Your Ref: OWQC17017
Our Ref: EP/154/17/HH
Please ask for:
Mr R Leal

26th January 2018

Rear roof extension
11 Worthing Road East Preston

PROPOSED ELEVATIONS 1:100@ A3

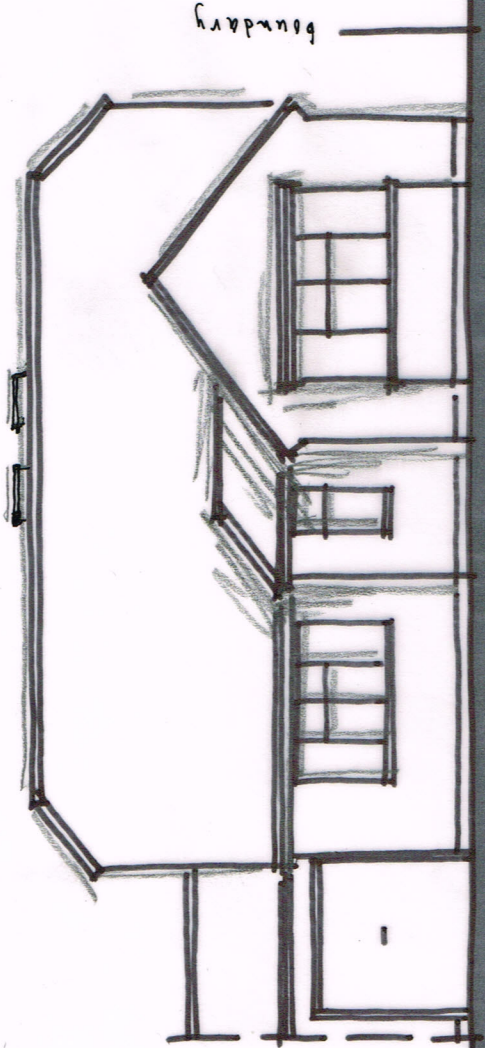
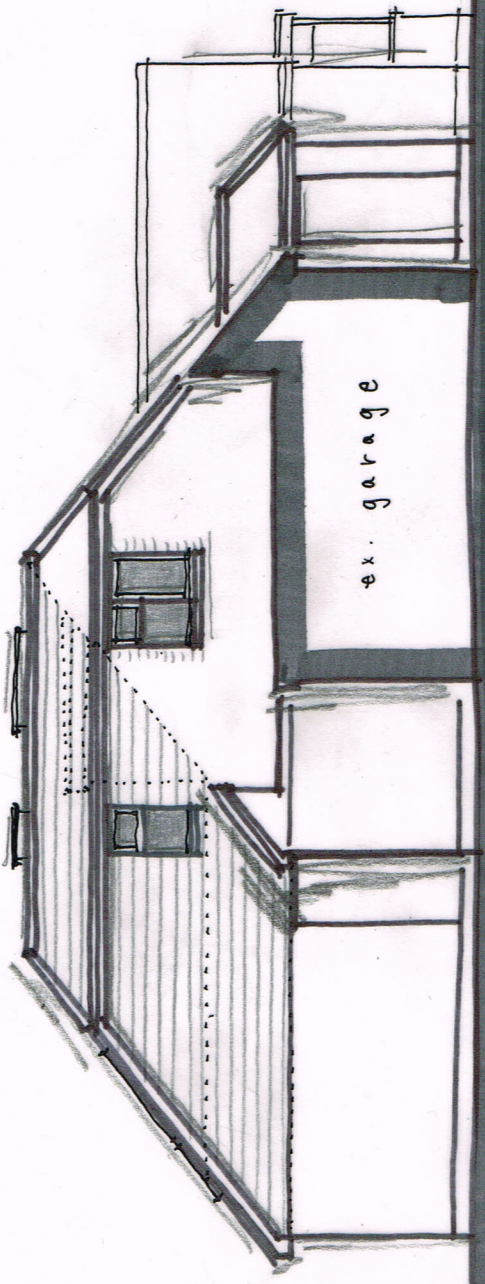
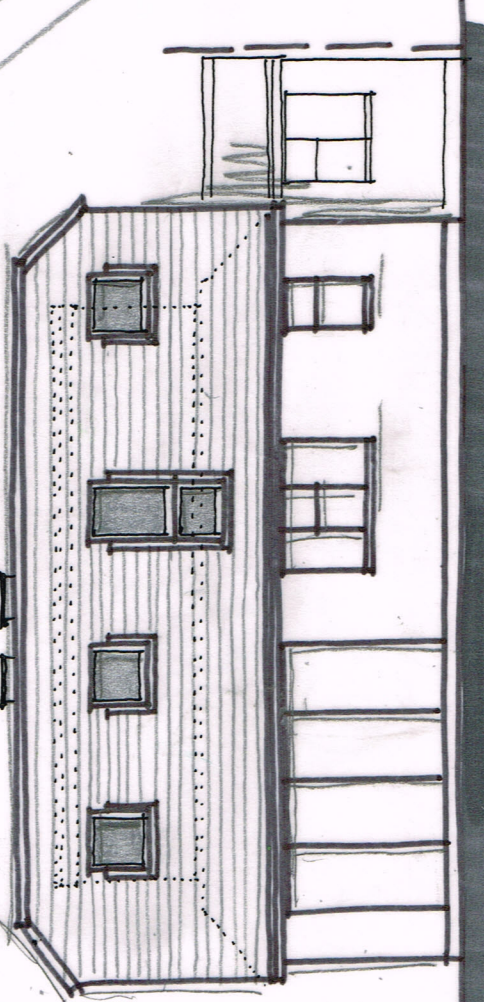
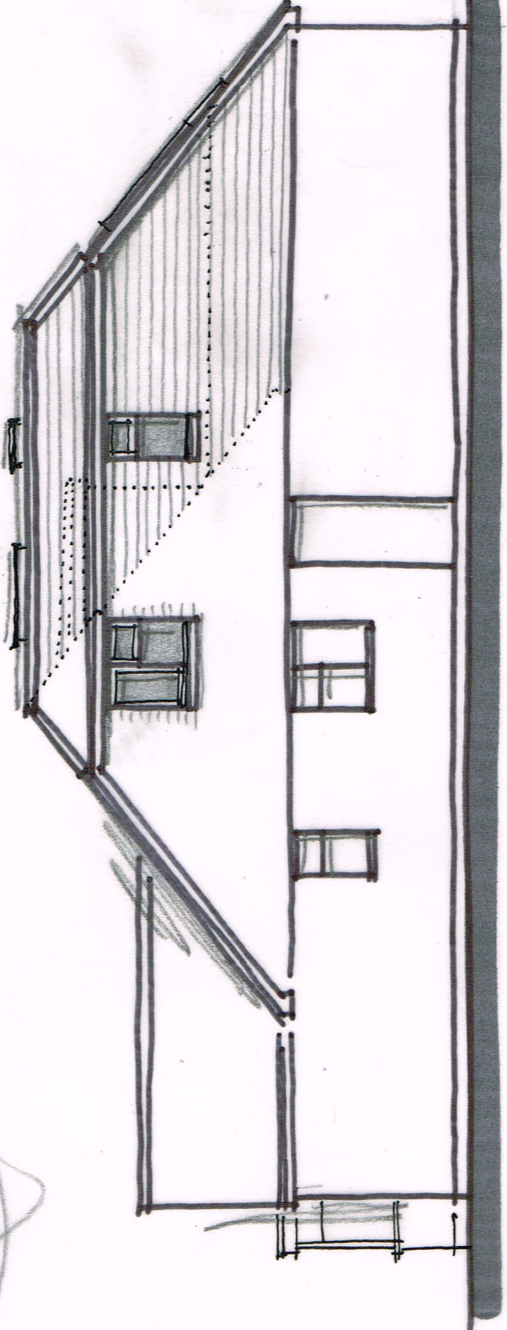
The committee agreed unanimously it would object to this Application as the scale and massing of the proposed extension would be unneighbourly, not subservient to the existing property and would not integrate with the existing property. The committee was concerned the additional windows on the eastern and western elevations of the property would have a negative impact upon the privacy of adjacent properties, the occupants of at least one of which have already contacted ADC to raise similar concerns.

This proposal is also contrary to several aspects of Policy D DM4 in the emerging Arun Local Plan as the proposed extension would neither relate to nor be visually integrated with the existing building in siting, massing, design, form, scale; nor would the extension be visually subservient to the main building and there is concern the pitch of the roofline would not provide a high standard of amenity and therefore also be contrary to Policy D DM4. The committee felt the proposed extension would have an adverse overbearing effect on neighbouring properties, again contrary to Policy D DM4.
